RFI

RFI #: 45
 Date: 1/27/2012
 Job: EB-02 Keller Springs Lofts
 Phone: 877-777-5115

CC: Enviro Design Landscape
 Subject: Relocation of fountain equipment vault

SHEET NUMBER
E-1.3

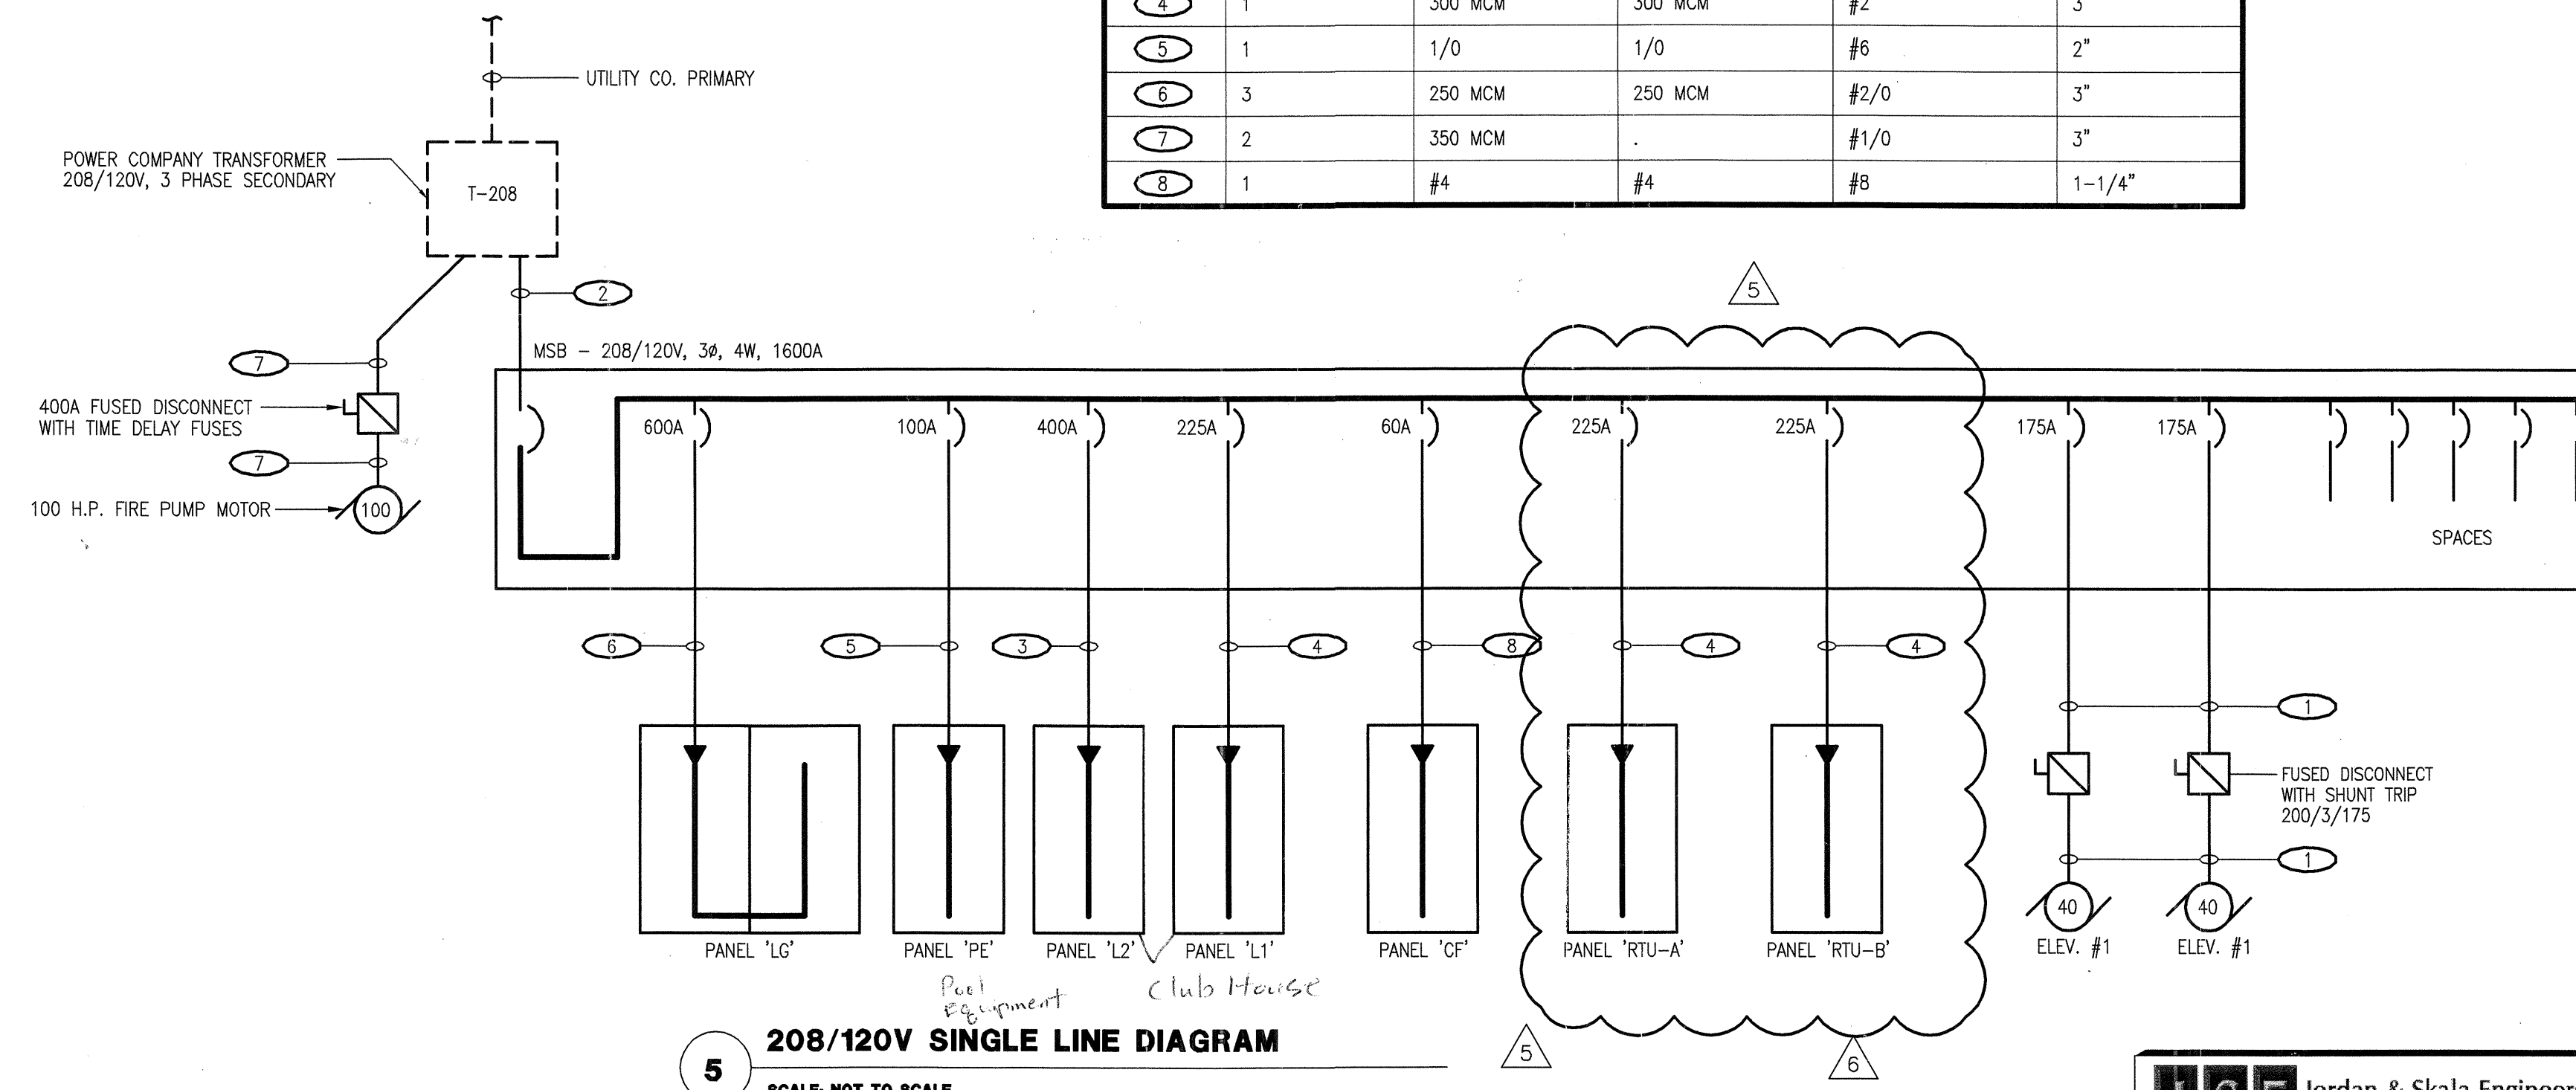
Request:
 On sheet E-1.3 on 12/21/11 a Panel 'CF' was added to the panel as a design revision. Is this for the fountain courtyard including the fountain equipment?

Sheet E-1.7 Panelboard schedule 'CF' has a note for contractor to coordinate with landscape and architect on location of 'CF' Panel. In talking with my electrician and pool contractor, we all feel the location for the CF panel should be located at the pop-out area in building between the patio's located to the southeast of the fountain equipment vault, which would be about 14' away from the power. By locating this panel in the courtyard, it would make any future changes or additions for the power requirements to the courtyard readily available.

Response: We are fine with the proposed location of the electric panel. We do have a proposed Japanese Yew that will be in conflict with the panel, so we recommend not installing the Japanese Yew and just filling the area in with Liriope groundcover.

JSE Response: Panel 'CF' serves the fountain courtyard and the fountain equipment.

Relocating the panel as noted by Enviro Design is acceptable.
 - Mike Jennings/Heath Parnell, Jordan & Skala 2/6/2012
